Appeal Decision

Appeal Ref: APP/R5510/W/22/330880

5 Carfax Road, Hillingdon, Hayes UB3 4RB

- The appeal is made under section 78 of the Town and Country Planning Act 1990 against a refusal to grant planning permission.
- The appeal is made by Mr Mahesh Mangara against the decision of the Council of the London Borough of Hillingdon.
- The application Ref 2359/APP/2022/1585, dated 16 May 2022, was refused by notice dated 11 July 2022.
- The development proposed is a change of use for the existing rear outbuilding from ancillary use to a residential self-contained residential studio unit with amenity and parking space.

REVISION:	REV A : UPDATED DRAWINGS
PROJECT:	5 Carfax Road Hayes UB3 4RB
DRAWING:	Location Plan & Site Plan
SCALE:	1:1250 / 1: 200 @A3
DATE:	Jan 2022
PAGE NO:	5 / P / 2022 - 01
STATUS:	PLANNING DRAWINGS

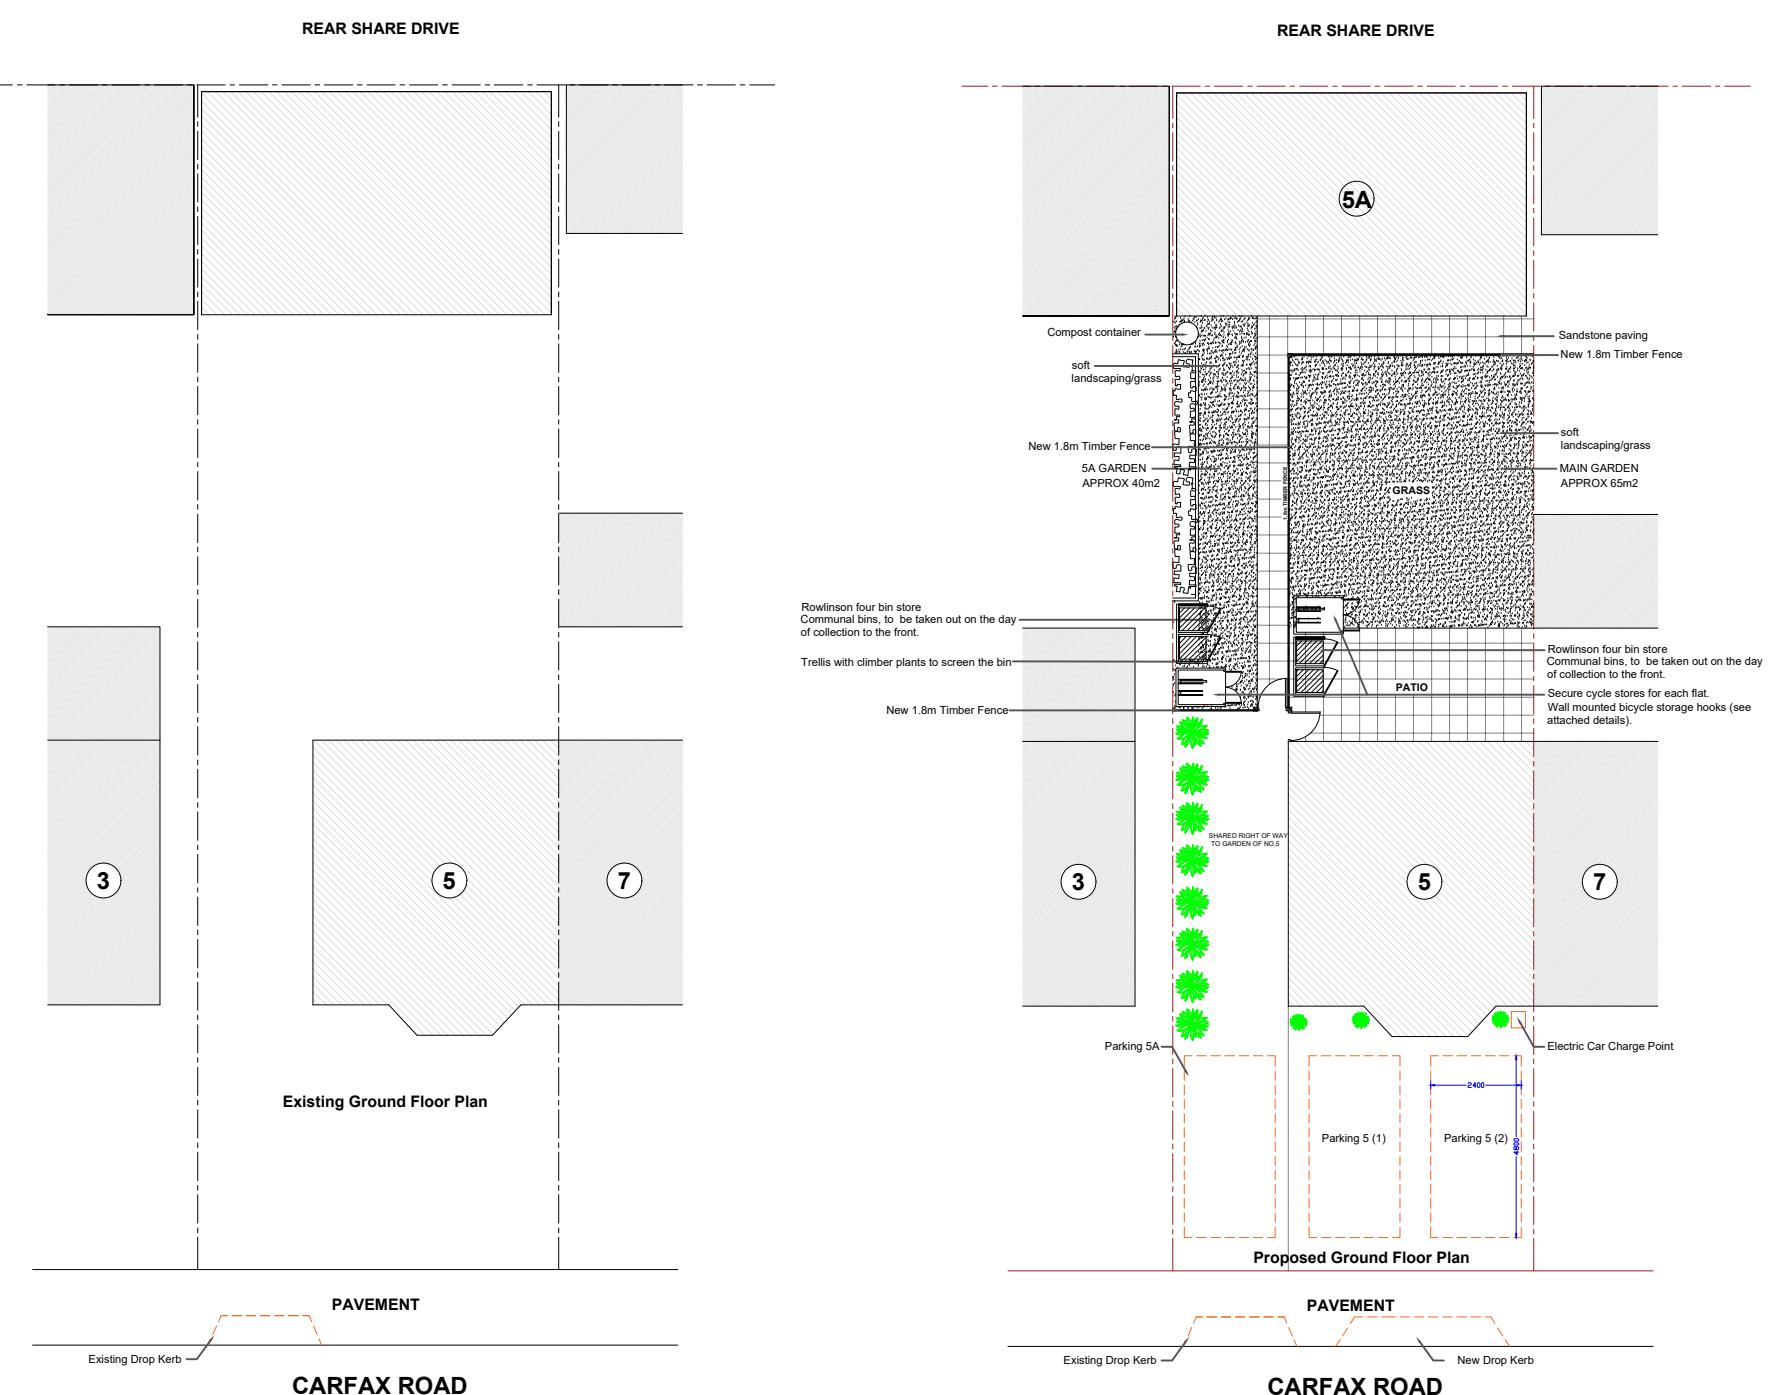
9. Secondly, the linear narrow shape of the outdoor space provided would be flanked by boundary treatments either side to safeguard the privacy of other neighbouring residents. However, this configuration, a notable section of which provides a pedestrian path to the dwelling, would constrain the usability of the space as well as lead to notable shadowing from the fences at certain times of the year. In addition, there are three upper rear facing windows of no.5 from which direct views over the garden area would be possible. Even though two were obscure glazed, the larger of these had a casement opening which would allow for views. Overall, this configuration would allow for an intrusive degree of overlooking to the modest garden area for the proposed dwelling. These factors would be likely to limit the activities, privacy and degree of sunlight that future occupants could enjoy.

11. Thirdly, the proposed car parking arrangements across the width of the frontage would leave only limited space between parked vehicles if all were occupied. This would present difficulties for pedestrians and/or cyclists seeking

to gain access to the proposed dwelling, garden of no.5 and the respective cycle storage shown. Hence, the layout would fall short of providing a clear and convenient route for future occupants as detailed in table 3.2 of the LP.

18. The proposal would subdivide the residential plot. Policy DMHB11 of the LP2 requires development to harmonise with the local context by taking into account, amongst other things, building plot sizes and widths. 1.8m high timber fencing would delineate the divided rear garden to create a broadly inverted L shaped plot for the proposed studio dwelling. This would reduce the width of the area associated with no.5 and provide a narrow garden area for the proposed dwelling. The resulting plot pattern would be more complex and alien in dimensions to the established pattern and so would not harmonise with

22. Furthermore, the proposal would formalise off-street parking arrangements to the front of the site, whereby three car parking spaces would span the width of the plot close to the road. Their presence would be clearly visible from the street thereby exacerbating a negative component of the street scene.

26. The proposal includes three off-street car parking spaces along the front of the site, with one space for the proposed dwelling and two for no.5. Cycle stores for the properties would be provided within the respective garden areas.

30. The parking configuration shown is problematic in that it omits to show suitable pedestrian visibility splays. Furthermore, as previously mentioned the limited space between the car parking areas would present an obstacle to pedestrians and cyclists seeking to access the rear of the site. An alternative arrangement⁴ suggested by the appellant could provide a 1.5m gap which would meet the absolute minimum width recommended by the TPDO. Although this also omits to show a pedestrian visibility splay, given the generally open aspect and low boundaries to frontages, I have little reason to doubt that suitable visibility could be achieved.

REVISION:	REV A : UPDATED DRAWINGS
PROJECT:	5 Carfax Road Hayes UB3 4RB
DRAWING:	Proposed Elevations
SCALE:	1:50 : @A3
DATE:	Jan 2022
PAGE NO:	5 / P / 2022 - 05
STATUS:	PLANNING DRAWINGS

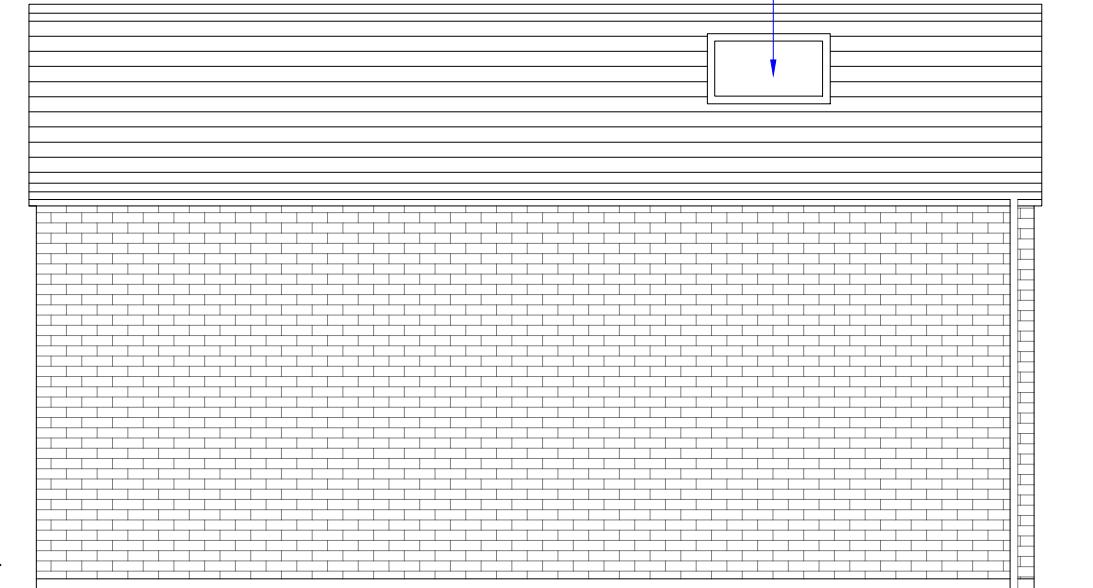
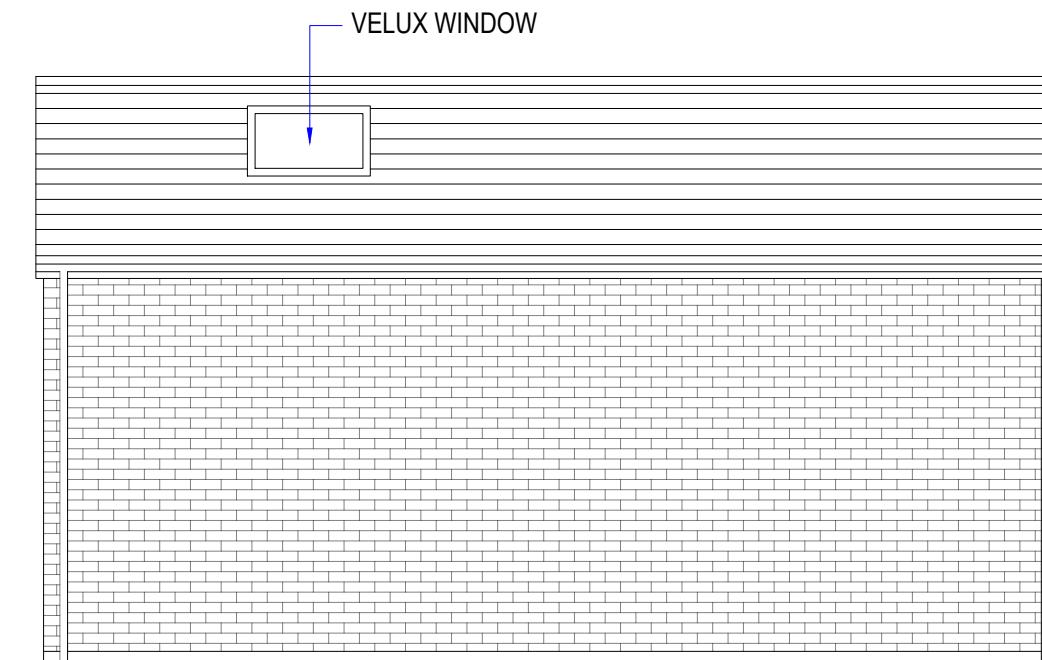
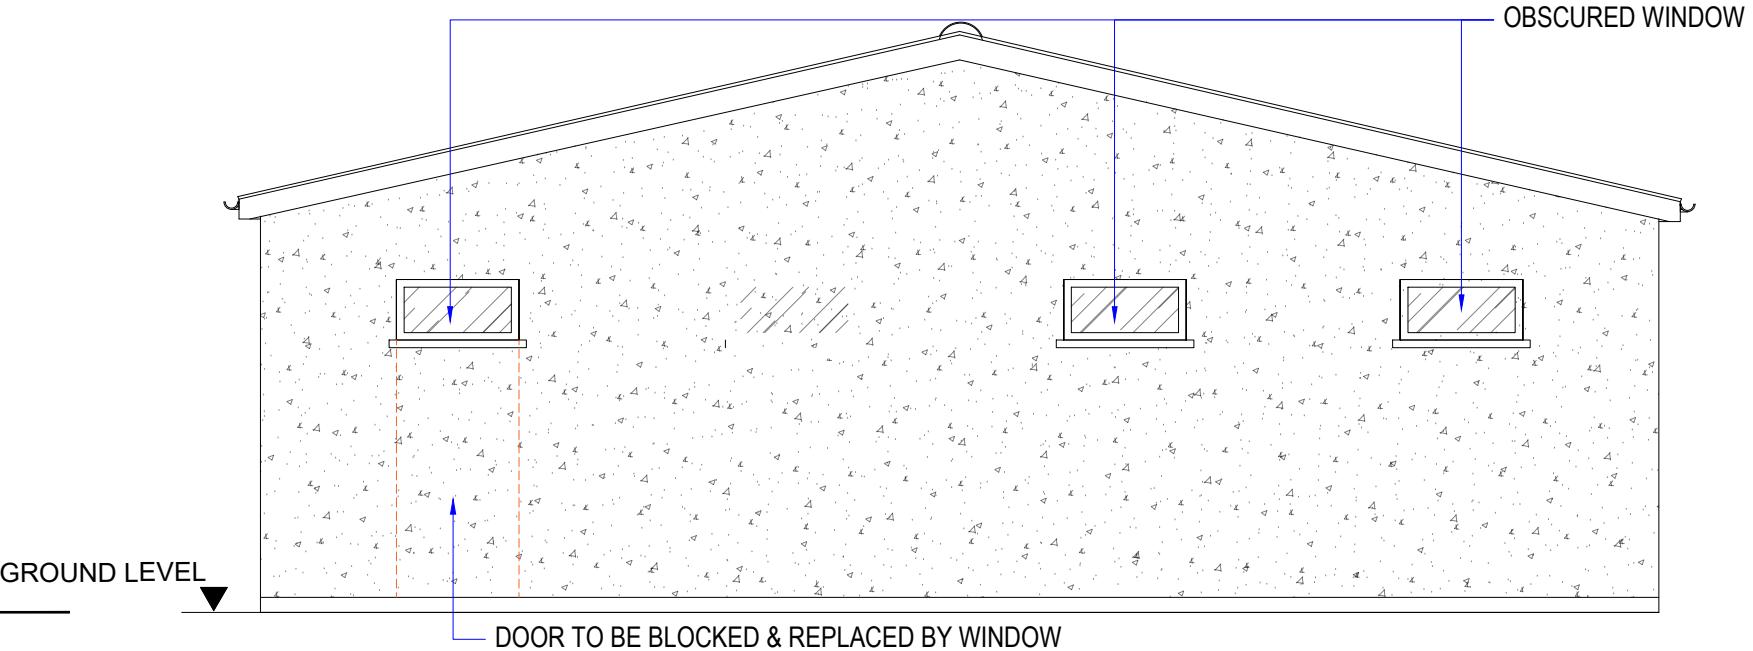
6. Firstly, most of the windows lighting the proposed studio dwelling would be obscure glazed or higher level roof lights. This would leave only the clear glazed kitchen window and access doors on the front elevation through which notable views out of the dwelling would be available to future residents. A 1.8m timber fence would be positioned in such proximity to the glazed access doors that it would dominate the outlook from the main entrance. Effectively, this would mean that only one window would have a longer view outwards, and as that window would have the kitchen sink in front of it, the main living space and bedroom areas would be denied a reasonable outlook.

REVISION:	REV A : UPDATED DRAWINGS
PROJECT:	5 Carfax Road Hayes UB3 4RB
DRAWING:	Proposed Floor Plan
SCALE:	1:50 : @A3
DATE:	Jan 2022
PAGE NO:	5 / P / 2022 - 04
STATUS:	PLANNING DRAWINGS

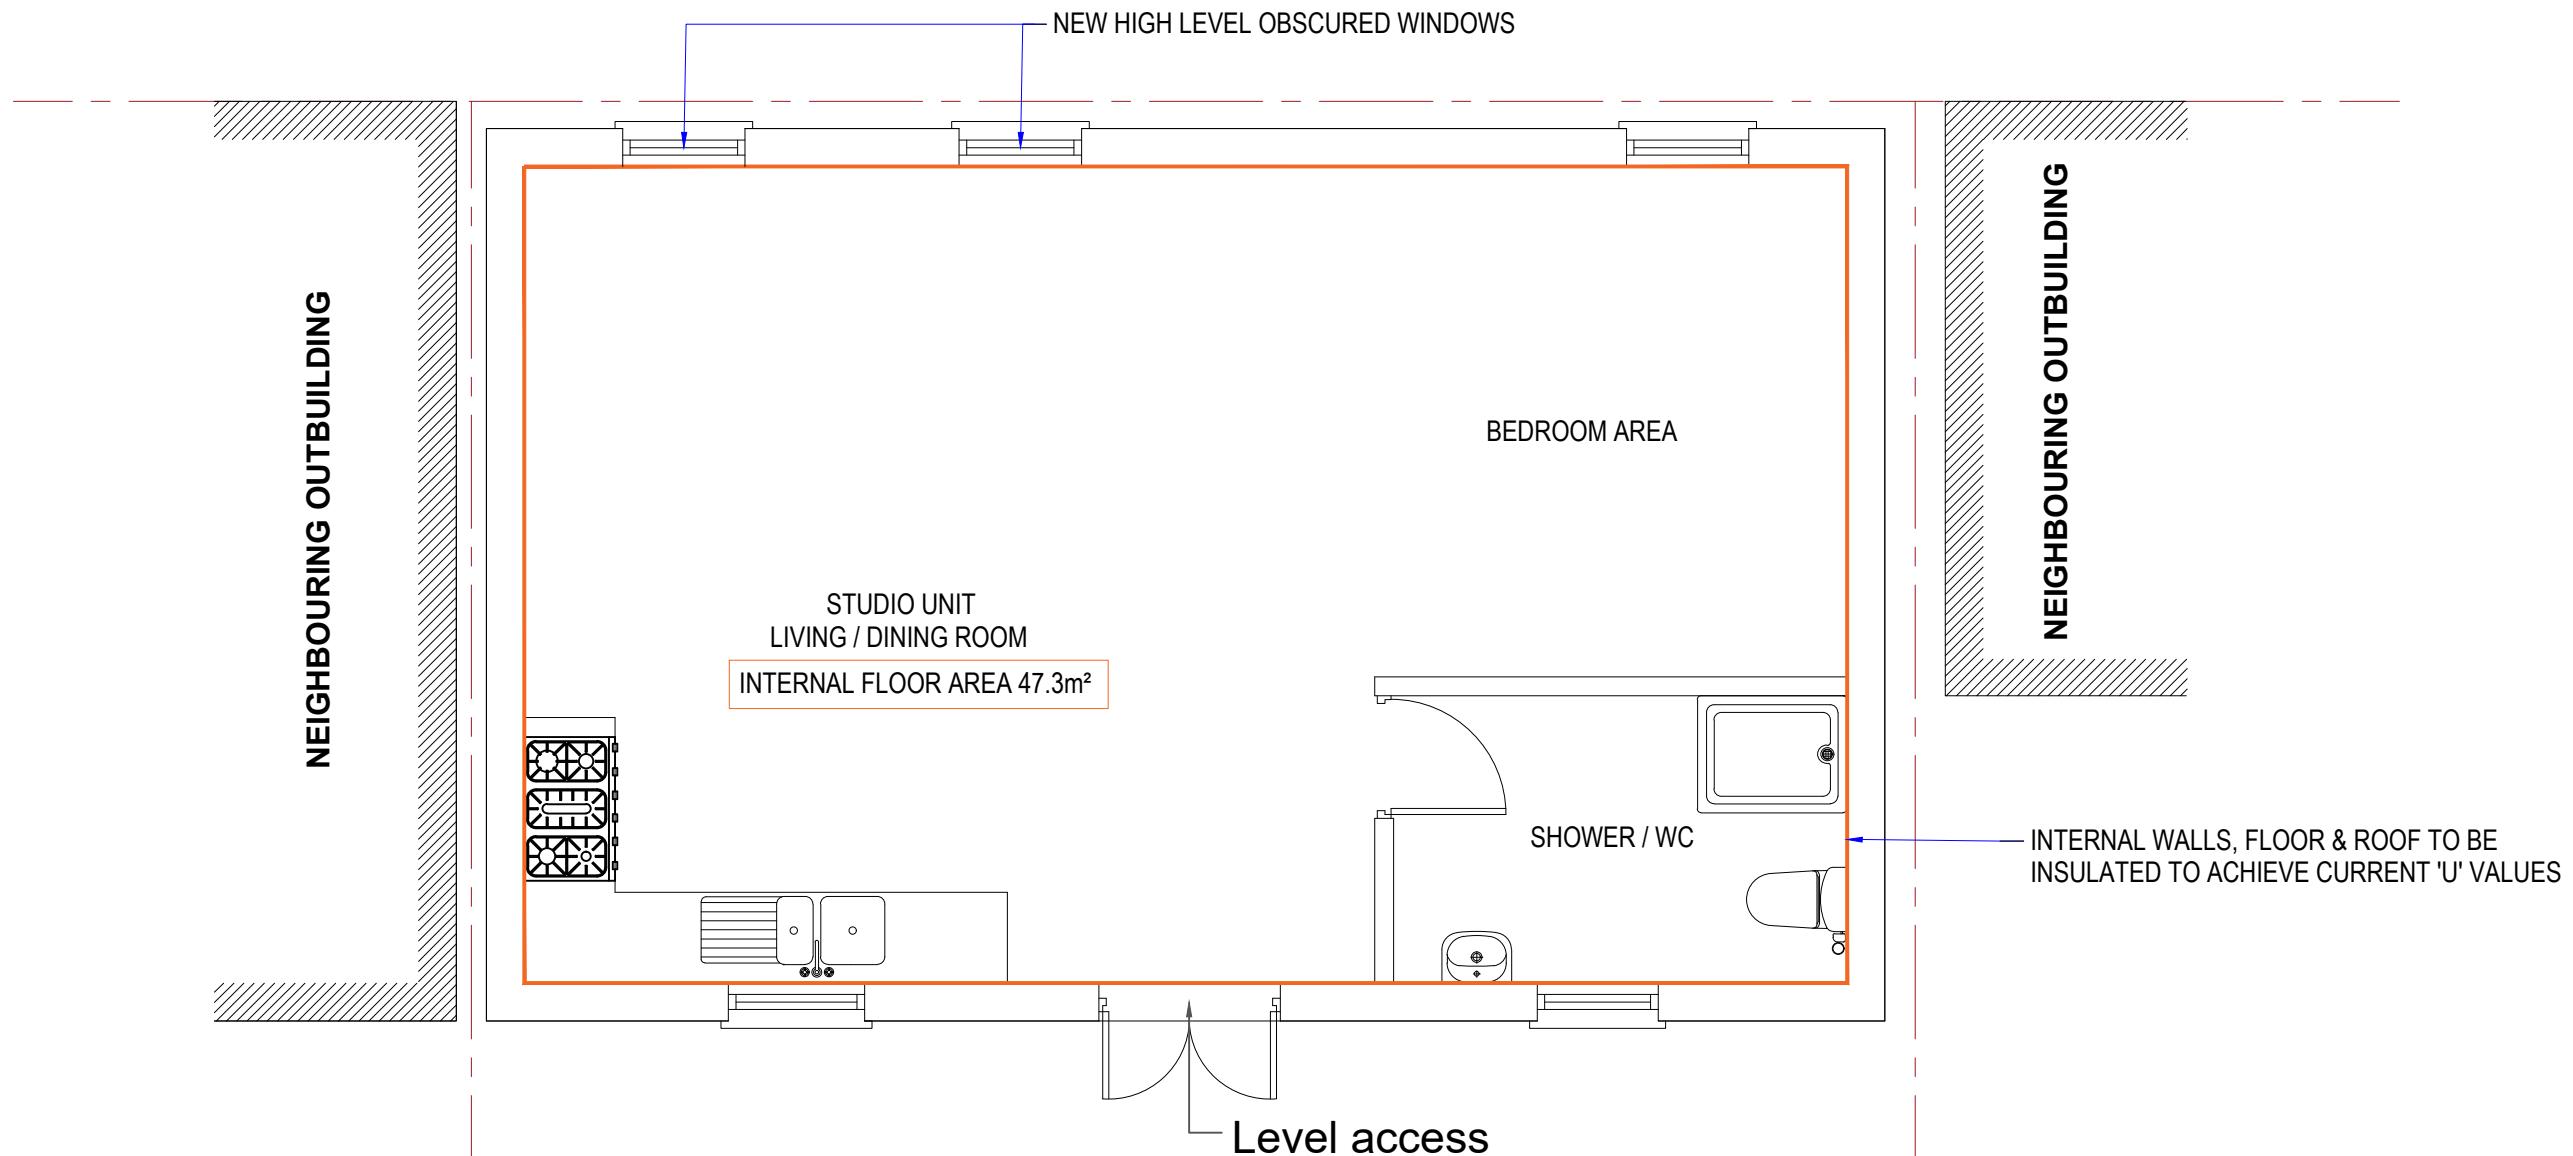
21. In addition, it is proposed to use the outbuilding as a main dwelling. The appellant points out that only minor physical changes would be made to the building. Therefore, its functional appearance and secondary scale relative to no.5 would remain. Hence, incongruity would arise from the discrepancy between the functional form and secondary position of the building and its proposed use. This would harmfully undermine the hierarchy and legibility evident in the established pattern of development which is intrinsic to the character of the area.
